**LOCATION: NC 105 - CONSTRUCT NEW BRIDGE OVER WATAUGA RIVER AND LEFT-TURN LANE AT SR 1112 (BROADSTONE RD.) WITHIN THE LIMITS OF R-2566B**

**TIP PROJECT: R-2566BA**

**REDLINE DRAINAGE  
 PLANS SUBMITTAL**

**7-16-2018**

PROJECT REFERENCE NO. <b>R-2566BA</b>	SHEET NO. <b>6</b>
RW SHEET NO.	
ROADWAY DESIGN ENGINEER 7/21/2021	HYDRAULICS ENGINEER 7/30/2021
<b>DOCUMENT NOT CONSIDERED FINAL UNLESS ALL SIGNATURES COMPLETED</b>

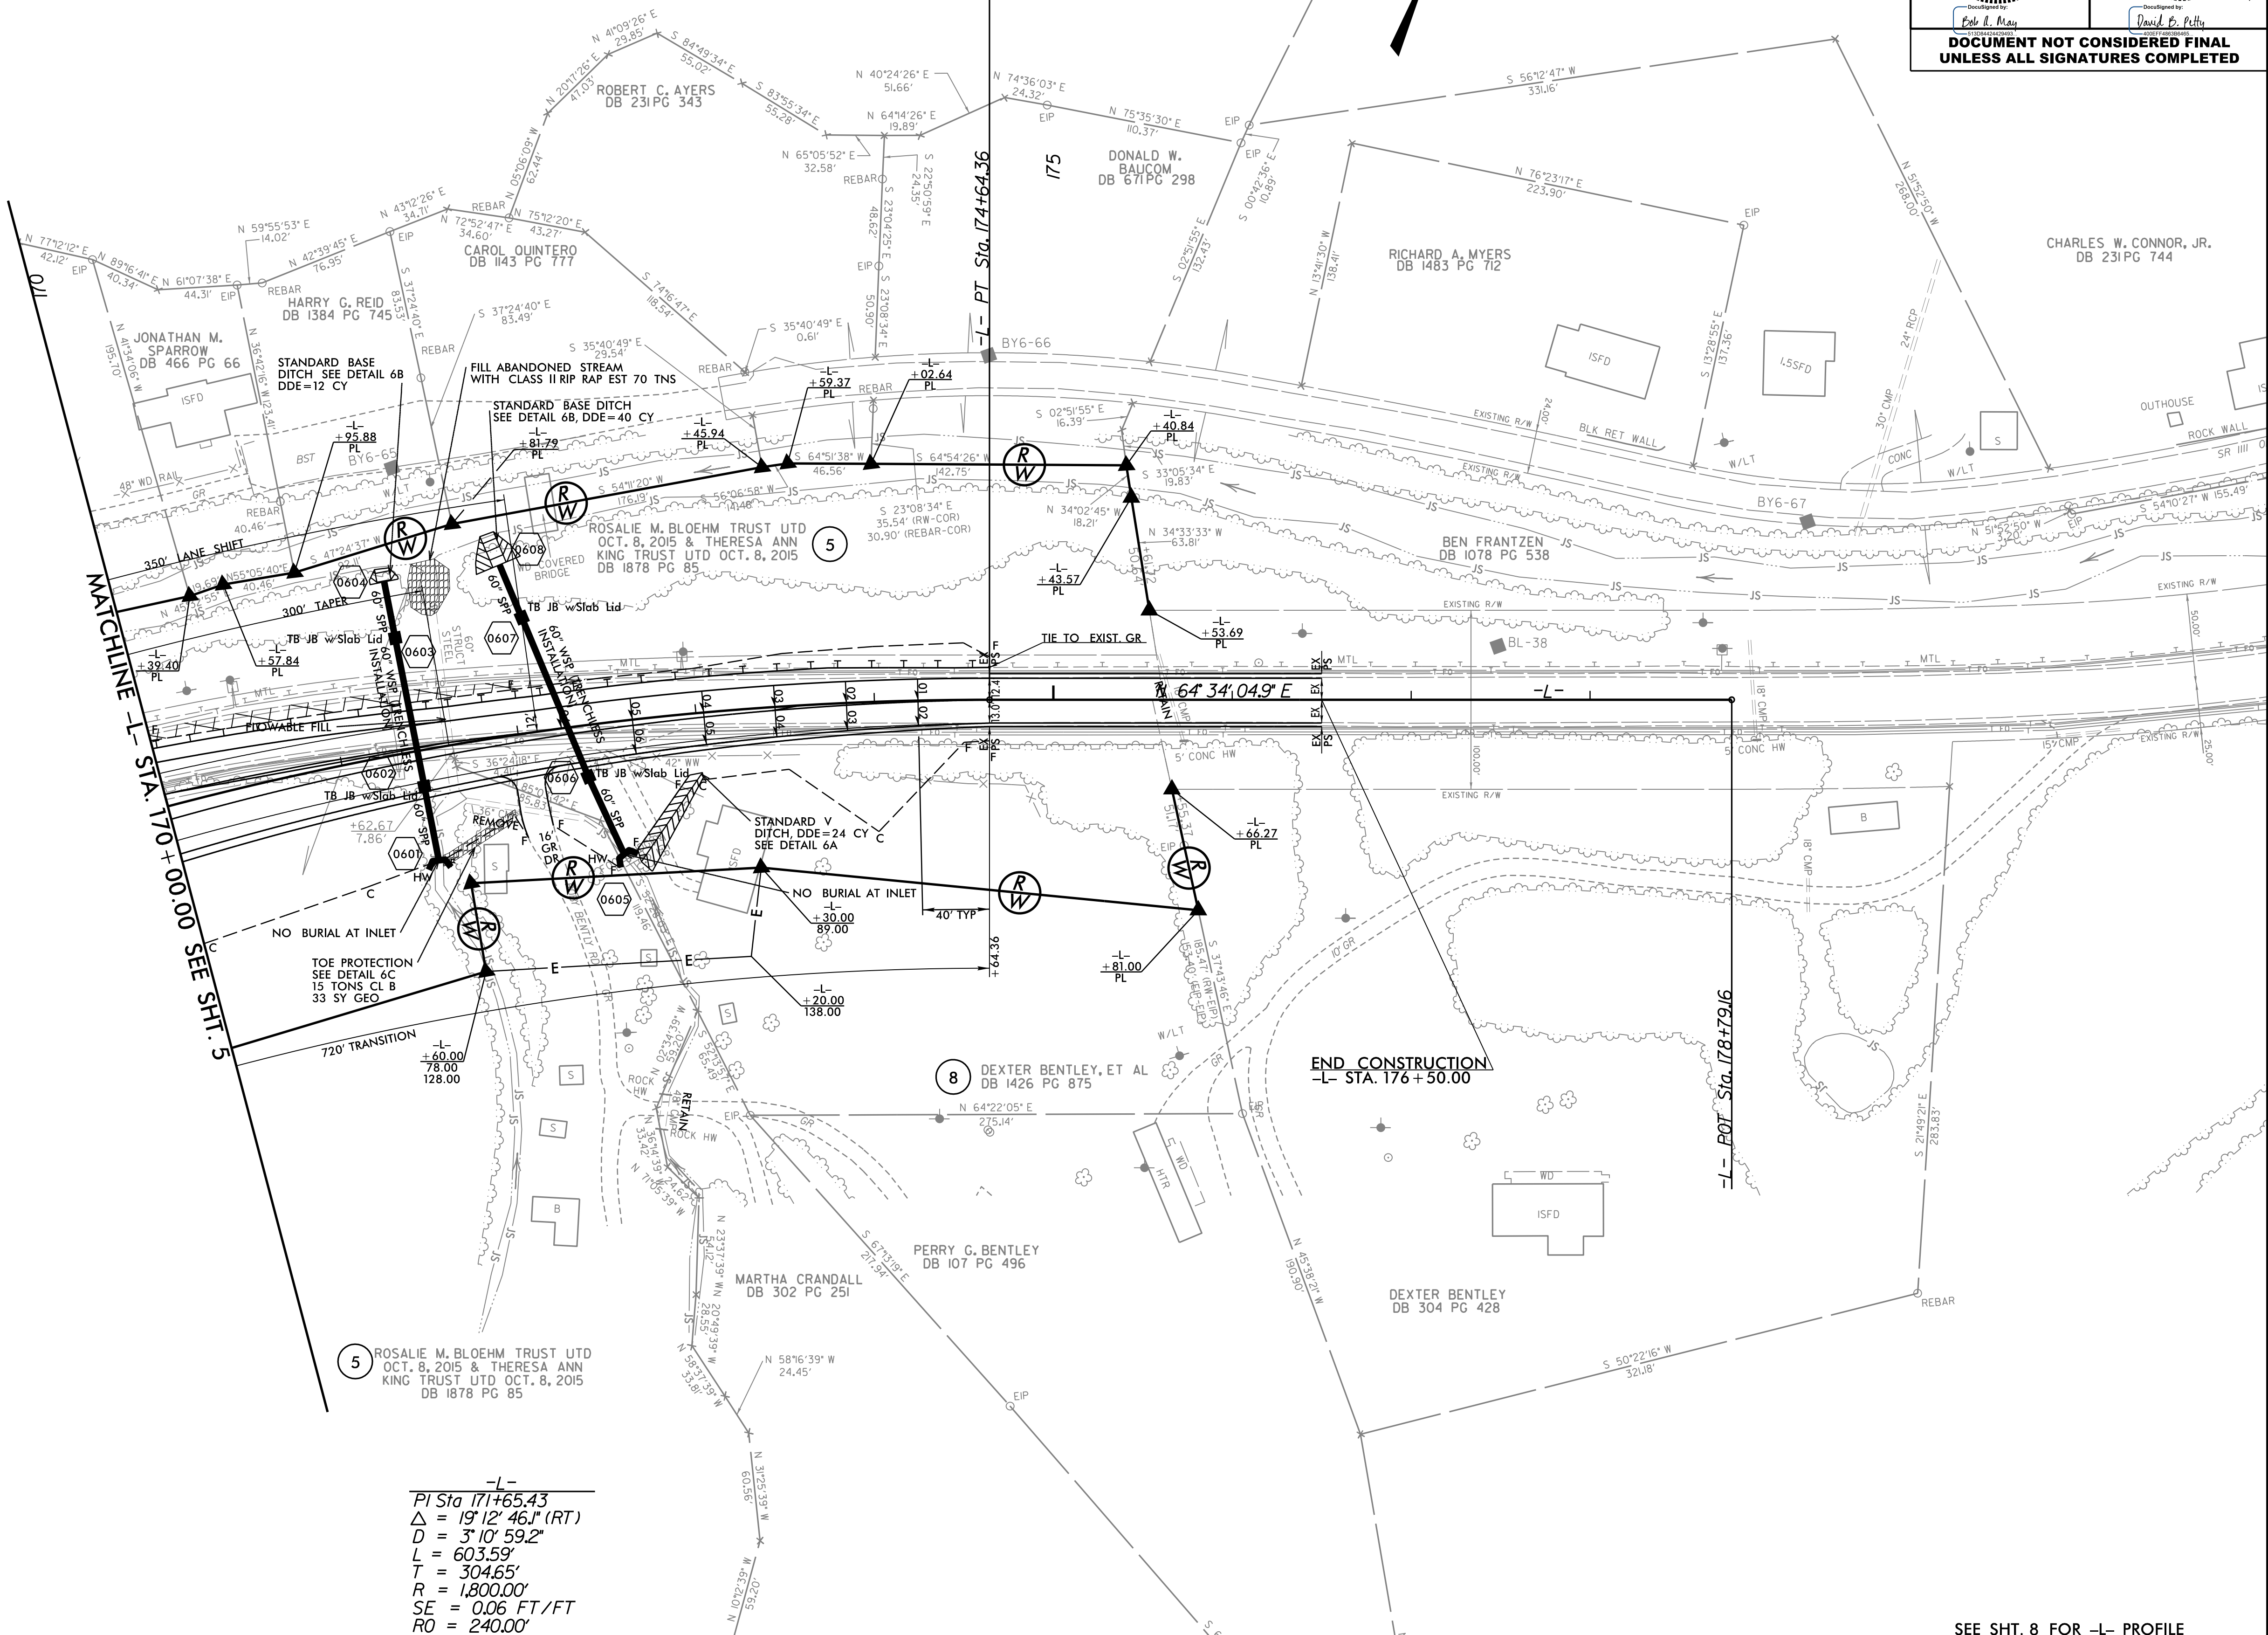
**DITCH CALCS.**  
 DA=207 cfs  
 Q10=130 cfs  
 n=0.049  
 S=1%  
 Base=10'  
 S=2.1, 2.1  
 V10=4.1 fts  
 d10=2.2 ft  
 Liner=Class I

DBP SPOKE TO GLENDA BENTLEY (828-773-3760) ON 5/21/18. GLENDA AND HER SISTER IN LAW, DEBRA, ALIGNED TO SMALL DBP PICS OF SUBSTANTIAL FLOODING IN LAST WEEK (HEADWATERS OF BOTH 60' & 36' CSP; HEADWATER OF 36' CSP UP IN YARD, BOTH AS HIGH AS REMEMBERED IN PERIOD OF KNOWLEDGE SEVERAL DECADES). DBP TO CONFIRM SIGNIFICANT SPINHOLES HAS FORMED AT DOWNSTREAM HALF OF 36' ROBY BENTLEY RD. IMPASSABLE SEE PICS EMAILED 5/21/18.
